From: Anita Gardner
Sent: 25 February 2019 11:27
To: Planning.Responses
Subject: FW: LU/357/18/PL - 18-22 East Street, Littlehampton, BN17 6AW

From: Kate Giddings
Sent: 25 February 2019 10:52
To: Anita Gardner
Cc: Anna Appleton
Subject: RE: LU/357/18/PL - 18-22 East Street, Littlehampton, BN17 6AW

From: Kate Giddings
Sent: 21 February 2019 17:27
To: Anita Gardner
Cc: Anna Appleton
Subject: LU/357/18/PL - 18-22 East Street, Littlehampton, BN17 6AW

Drawing Title
Existing - Plot 22
Lower Ground, Ground &
First Floor.

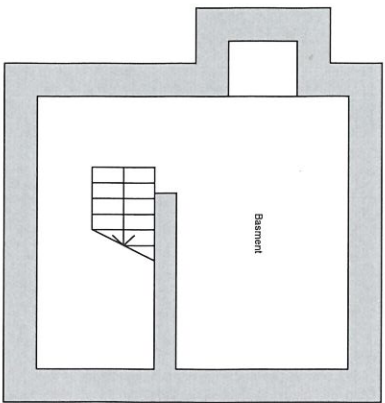
- More details is required regarding the proposed plant room occupying the lower ground floor of no. 22 East Street (including the type of plant, hours of operation, noise-reduction measures, etc.)
